KITTITAS COUNTY

MEMORANDUM

TO: All Staff
FROM: Justin Turnbull, County Surveyor 
DATE: August 23, 2021
SUBJECT: County Survey Review of LPF-21-00008 Palomino Fields Div VII

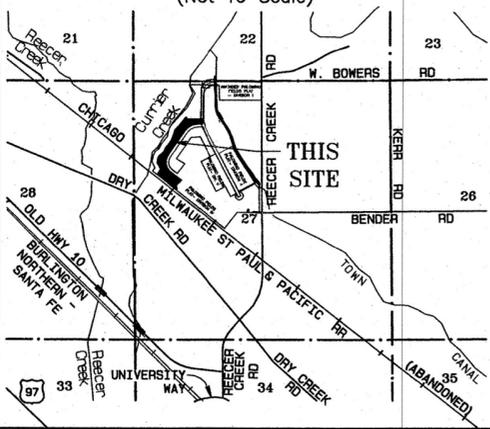
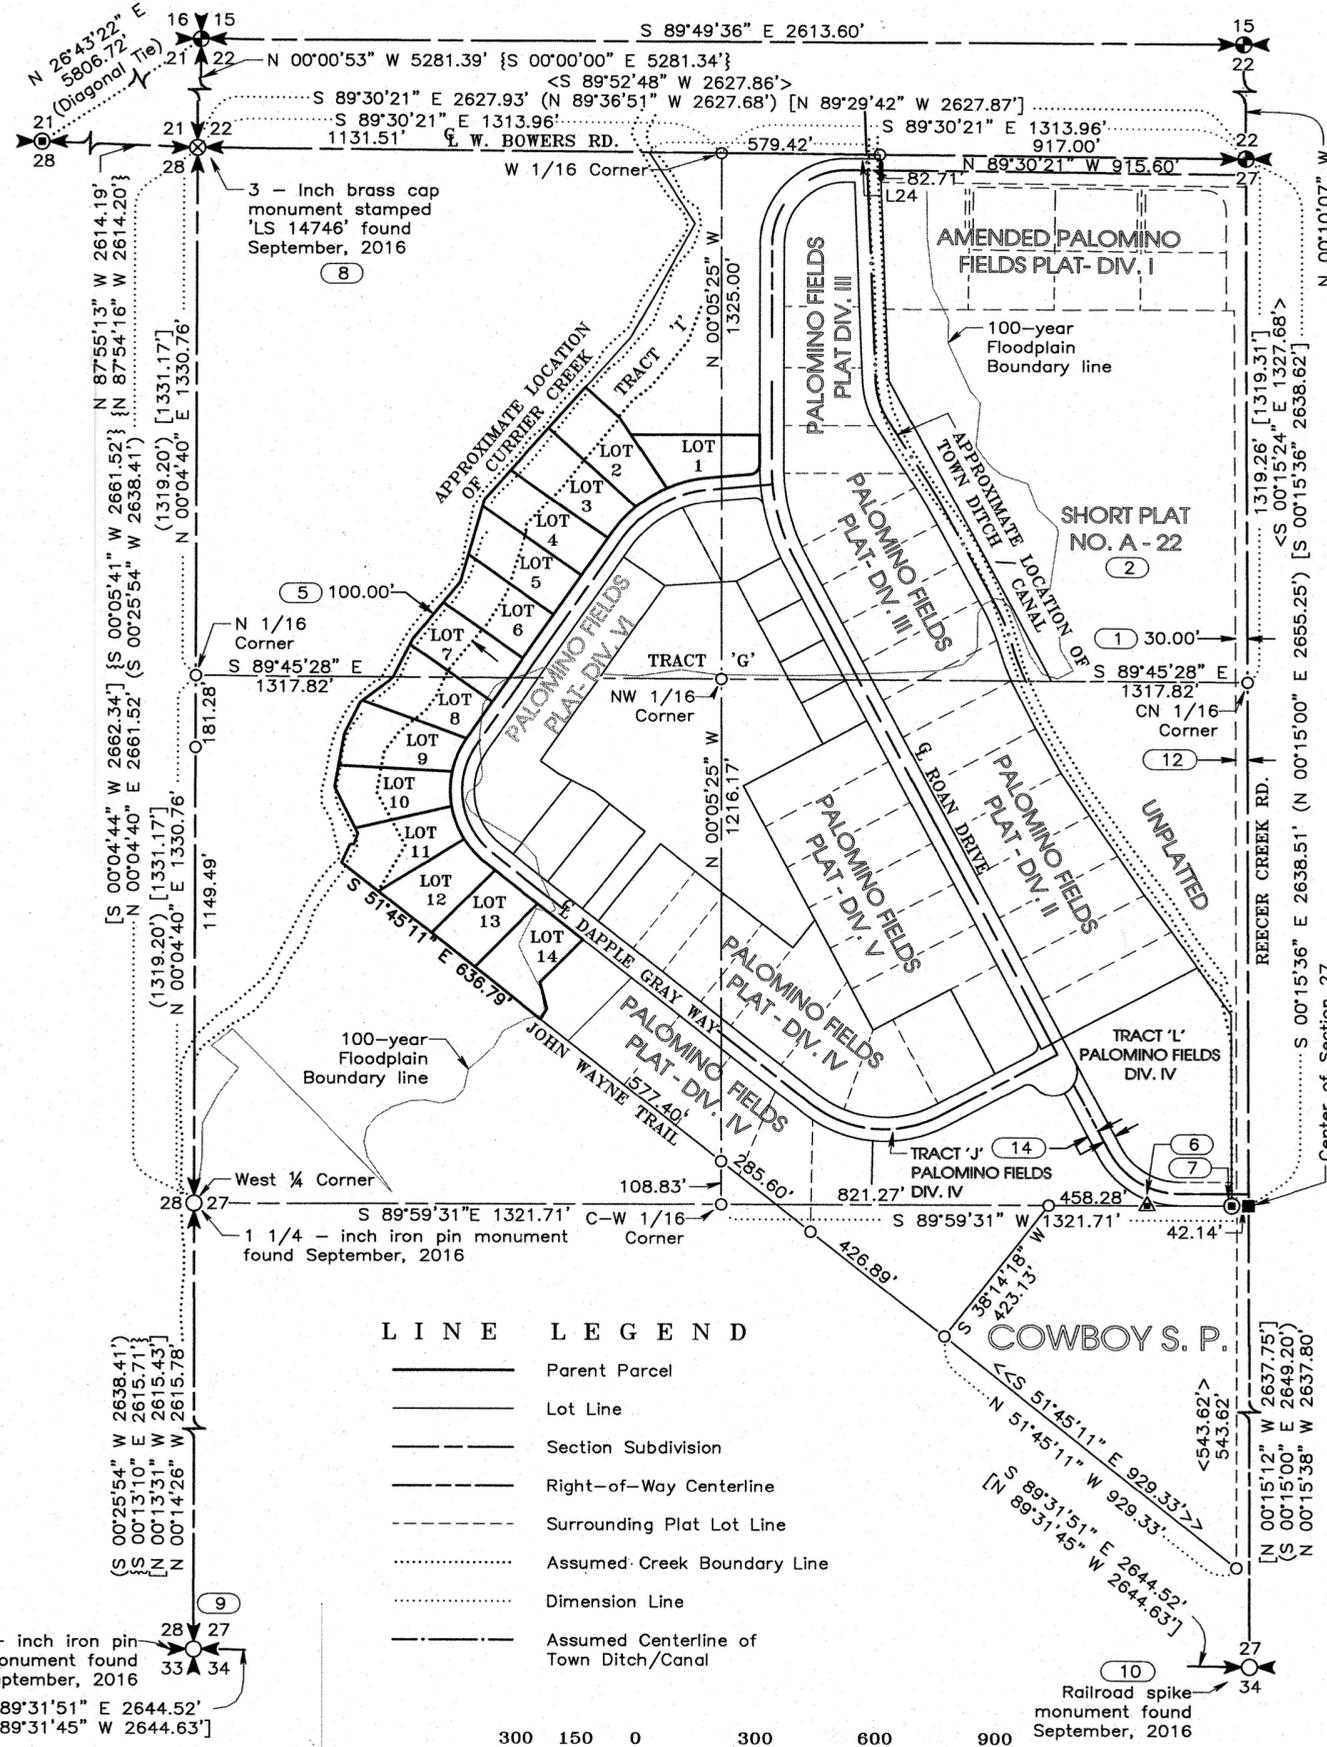
Sheet 1

1. The text "C/L W. Bowers Rd." incorrectly appears on the N line of Nw1/4 Nw1/4 Sec 27.

Surveyed by LMH Scale 1" = 100'  
 Drawn by Tml/FCS Sheet 2 of 5  
 Checked by RNS Project No. 18146

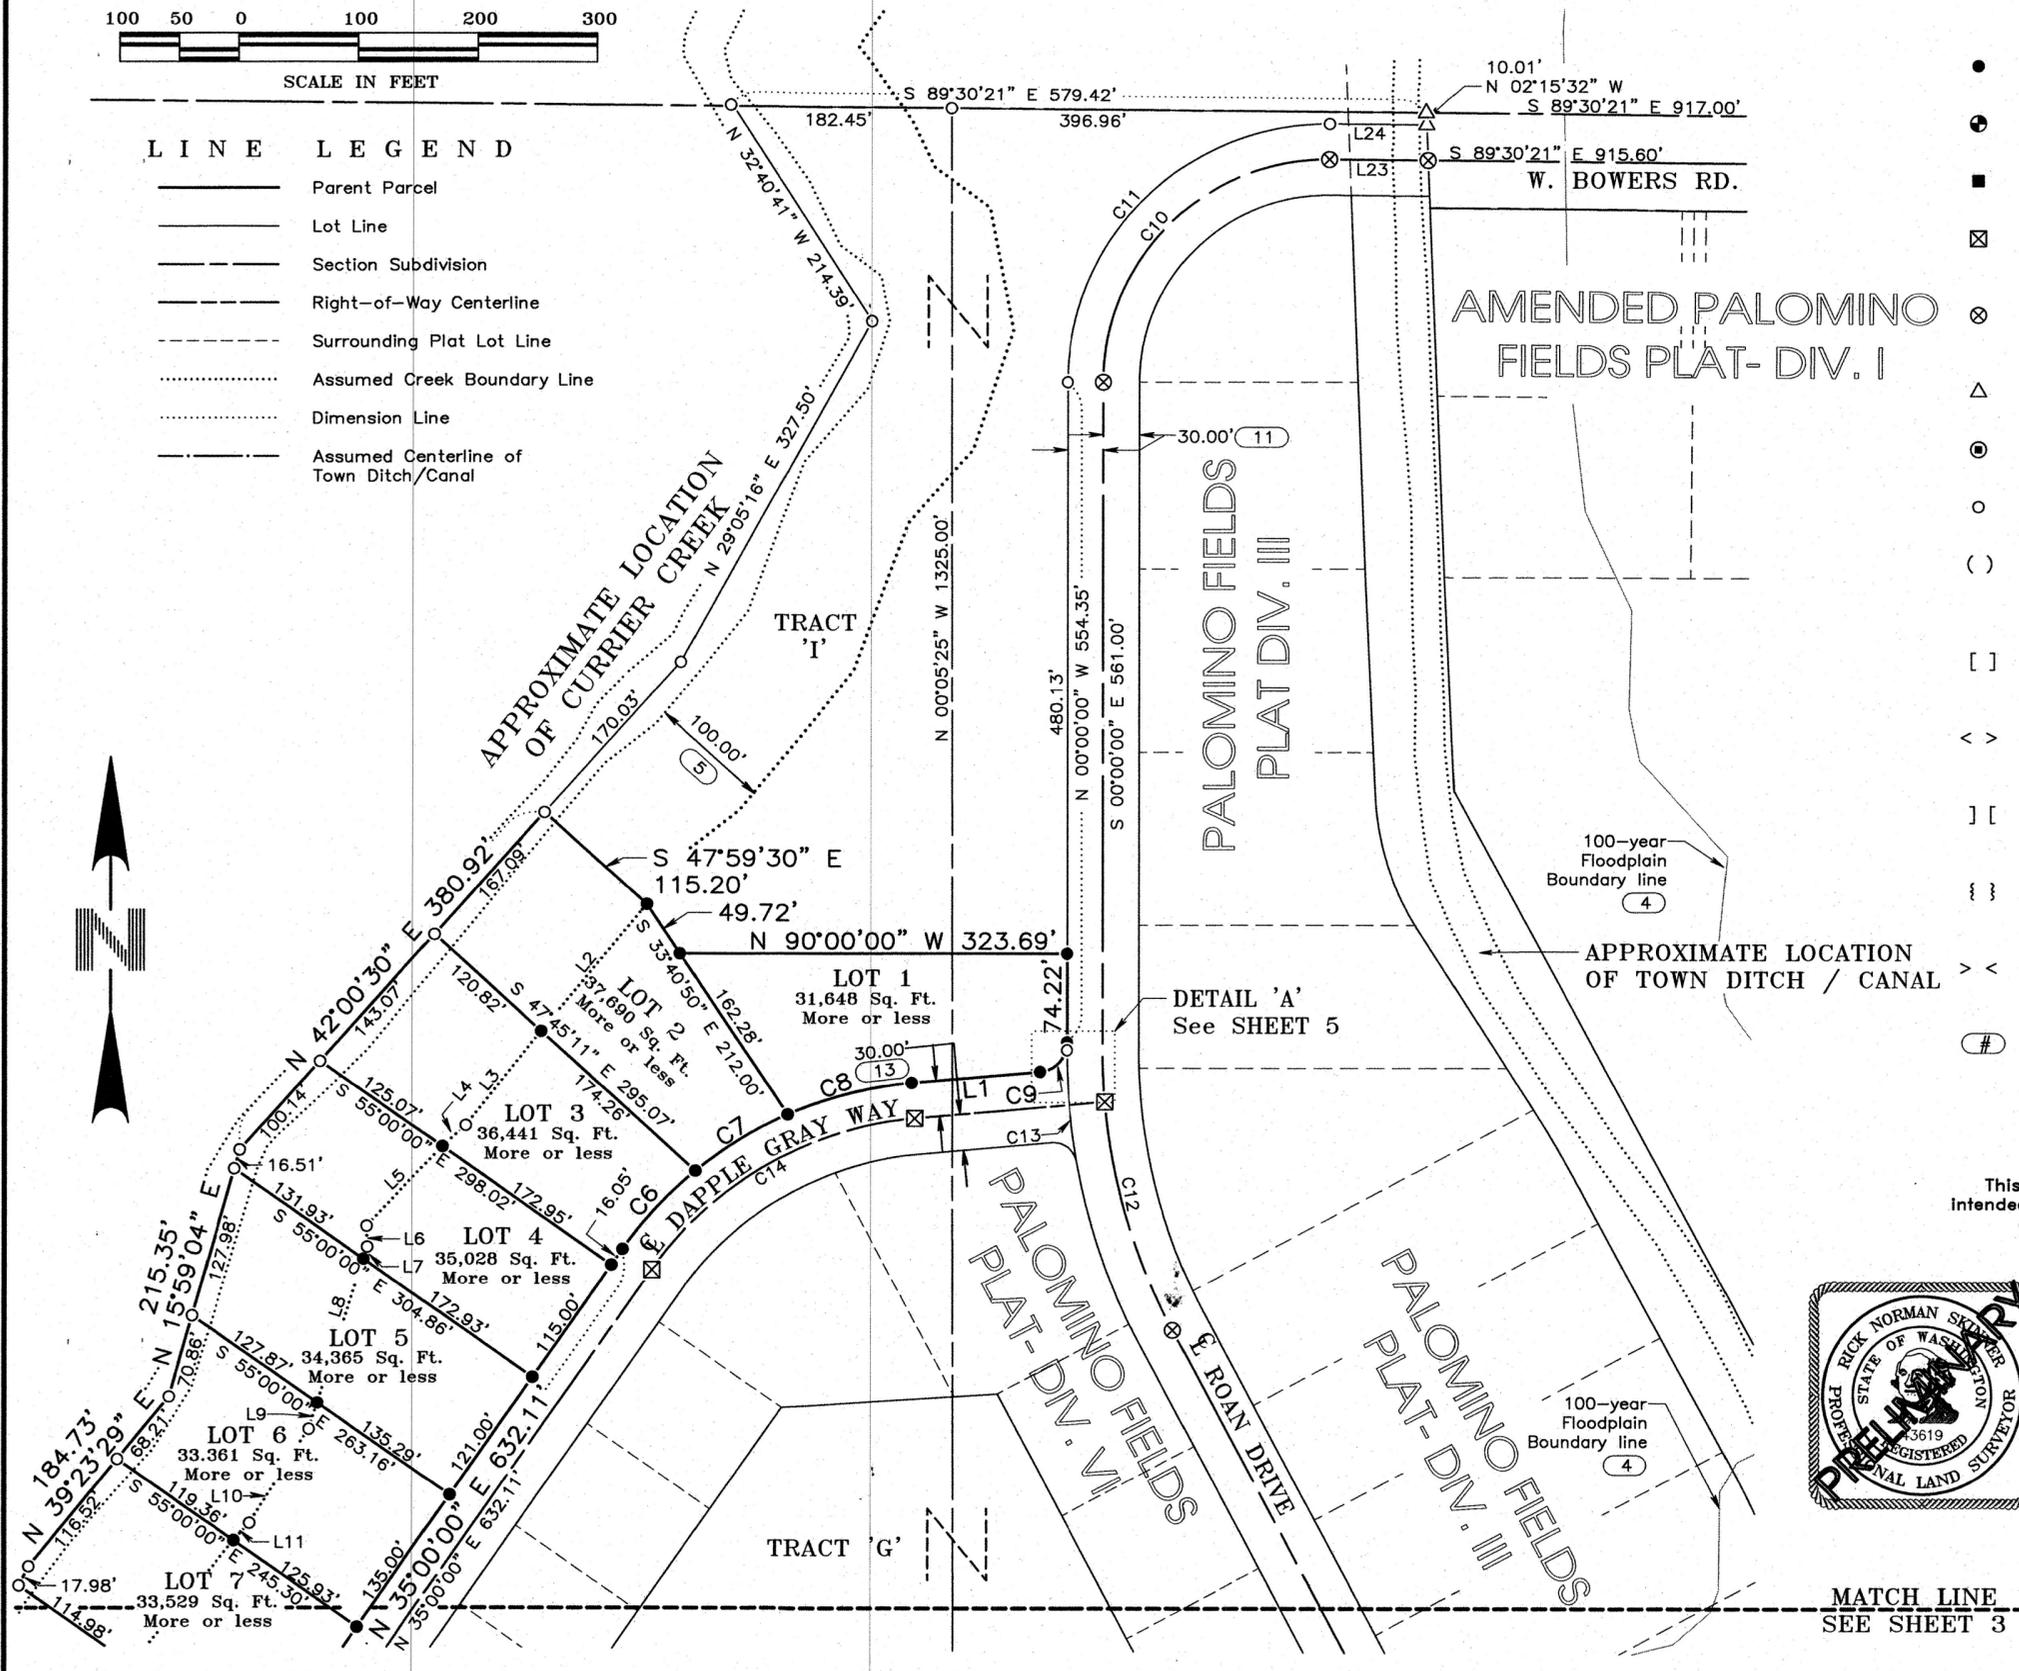
Sheet 2

2. Tract 'I' does not show an area. Also, it is not included in the Closure report. Applicant is expected to ensure that the closure report matches the plat. (No need to resubmit new closures)
3. The NW' most line of Lot 2 does not match the closure report.

Surveyed by LMH Scale 1" = 100'  
 Drawn by Tml/FCS Sheet 3 of 5  
 Checked by RNS Project No. 18146

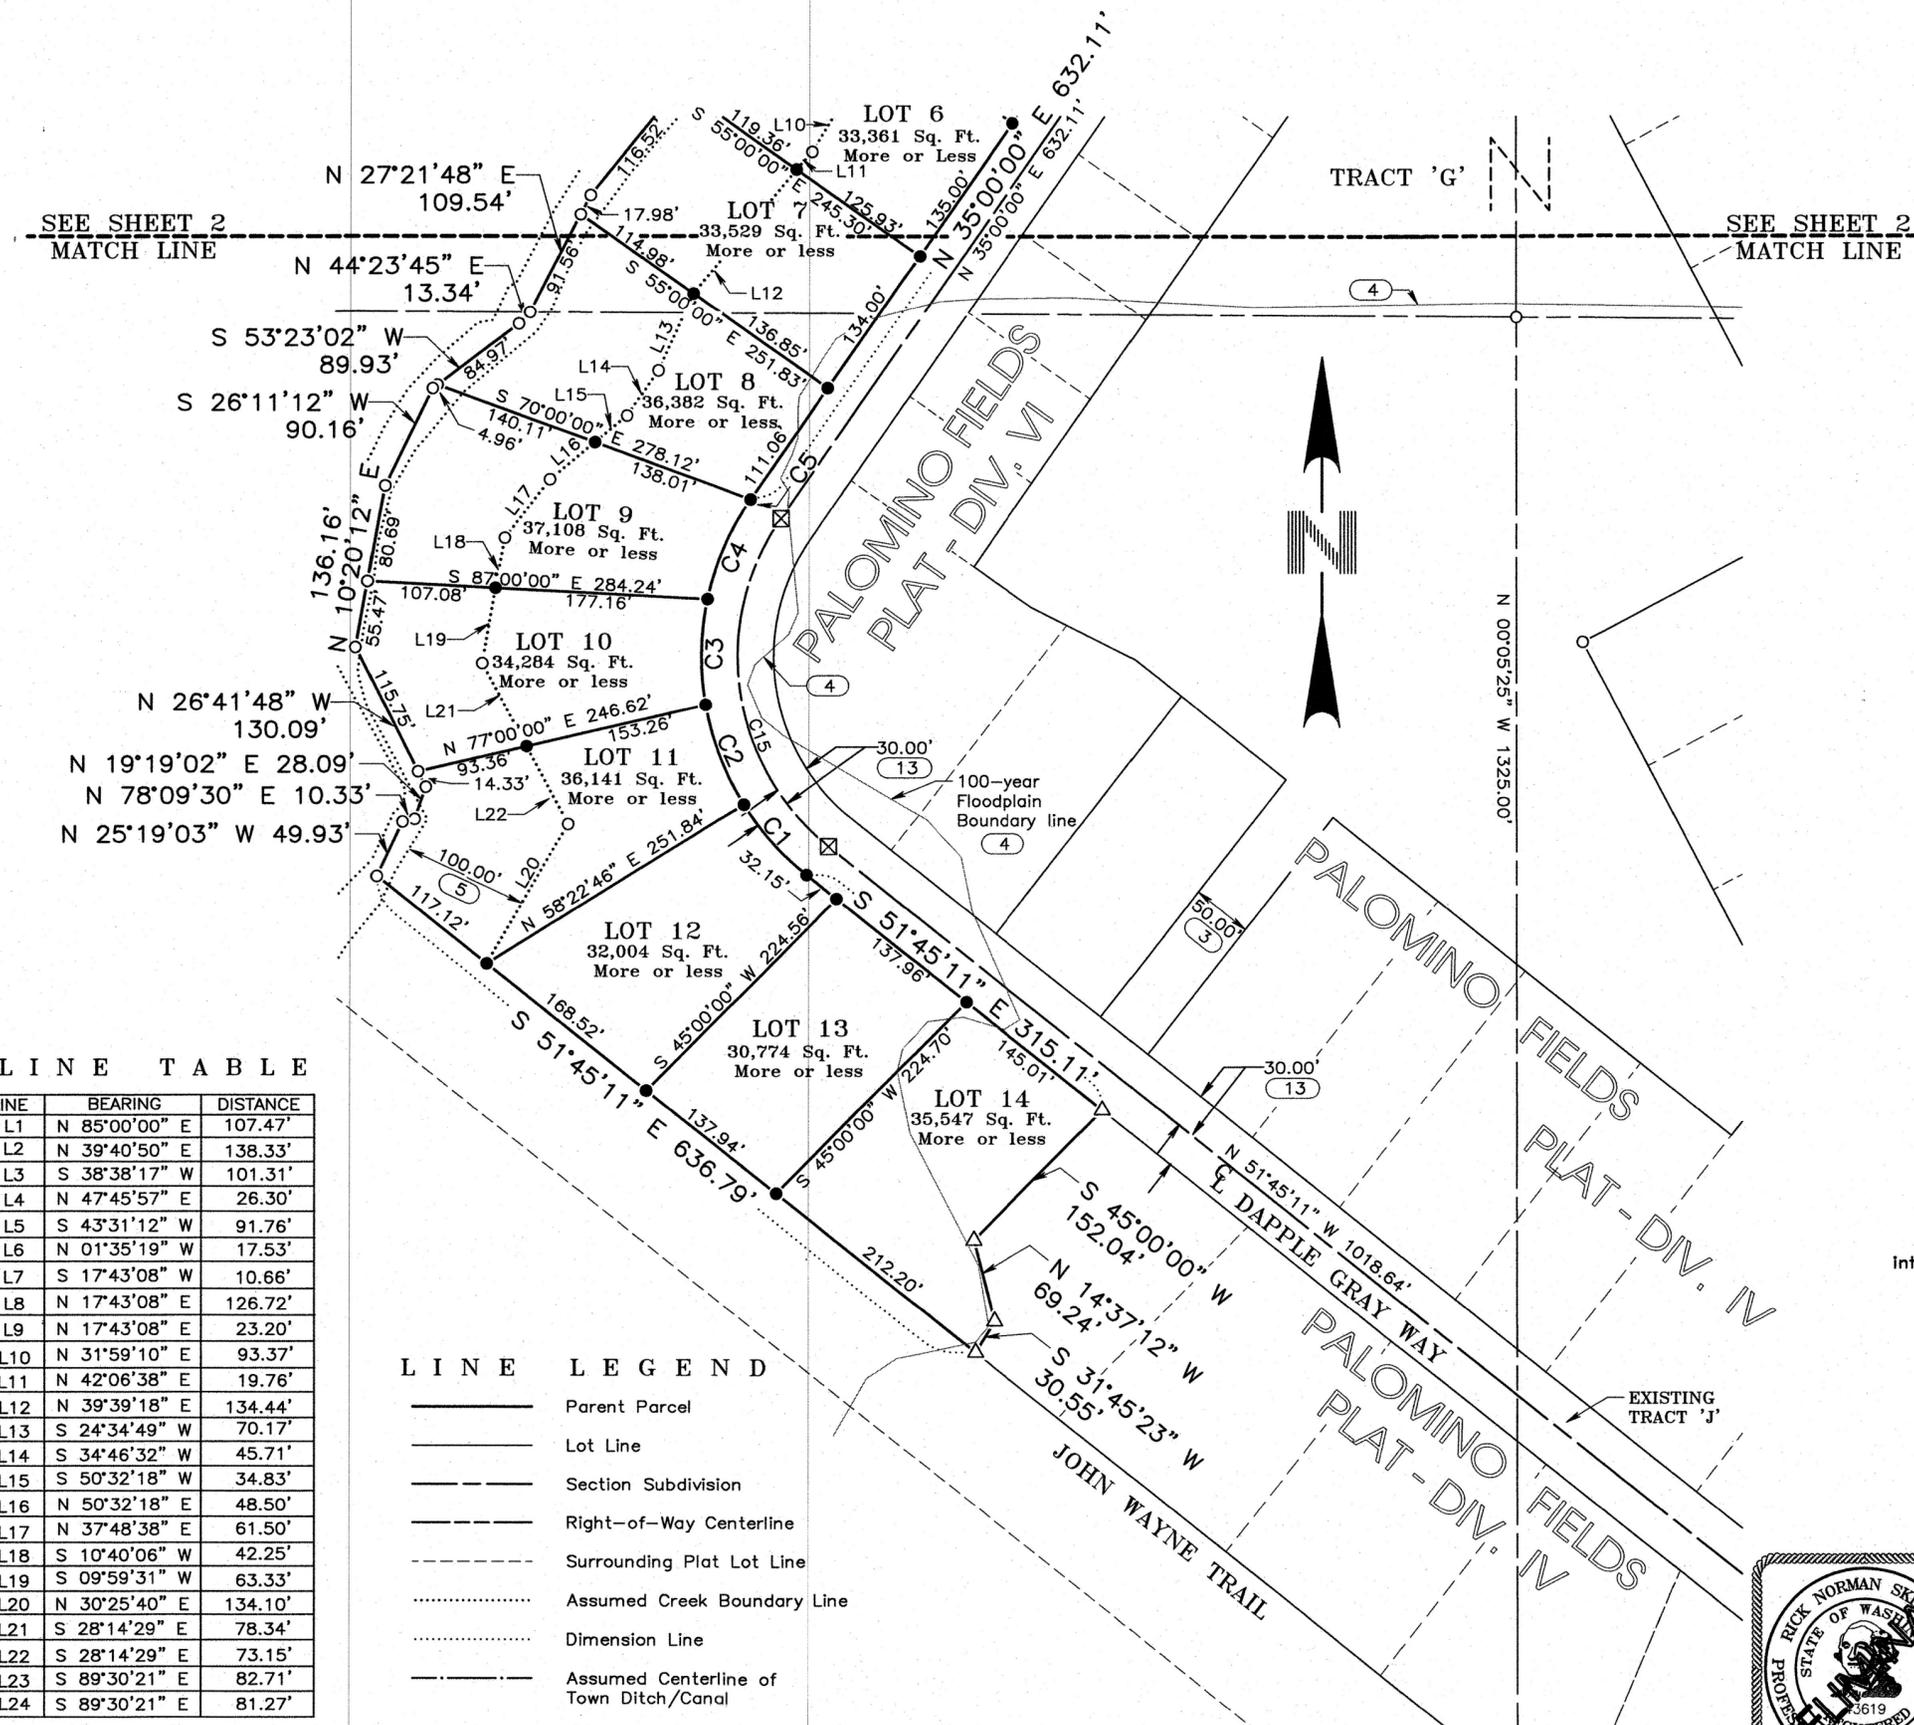
Sheet 3

4. The area of Lot 7 does not match the closure report.
5. The SW' most line of Lot 12 does not match the closure report (bearing and distance).
6. The SW' most line of Lot 13 does not match the closure report (bearing).
7. Please make it clearer that Curve 'C5' is part of Lot 8.

### ORIGINAL PROPERTY DESCRIPTION

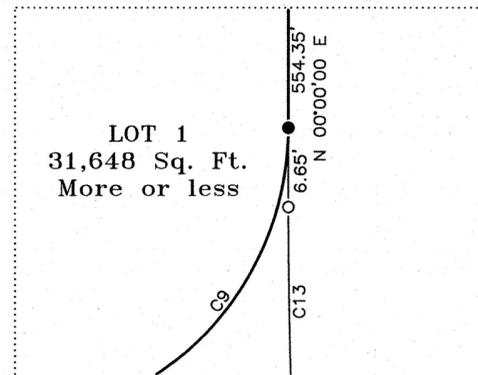
Sheet 4

8. Plat note 15 is shown as Plat Note 51.
9. Change Original property description from "Tract H" to "Tract E". Also please revise the AFN to 202101210112.
10. Please include the following Note:

All private roads shown hereon are hereby conveyed to Palomino Fields Utilities Inc. (PFUI) upon the recording of this plat. Except as otherwise noted hereon, PFUI is hereby responsible for all

maintenance and management obligations associated with said road. Should PFUI fail to properly maintain said road, the owners of Lots 1 through 14 shall be equally responsible for maintenance of said road.

** Include Tract I in the above statement if Tract I is intended to be managed by PFUI or a homeowners association.
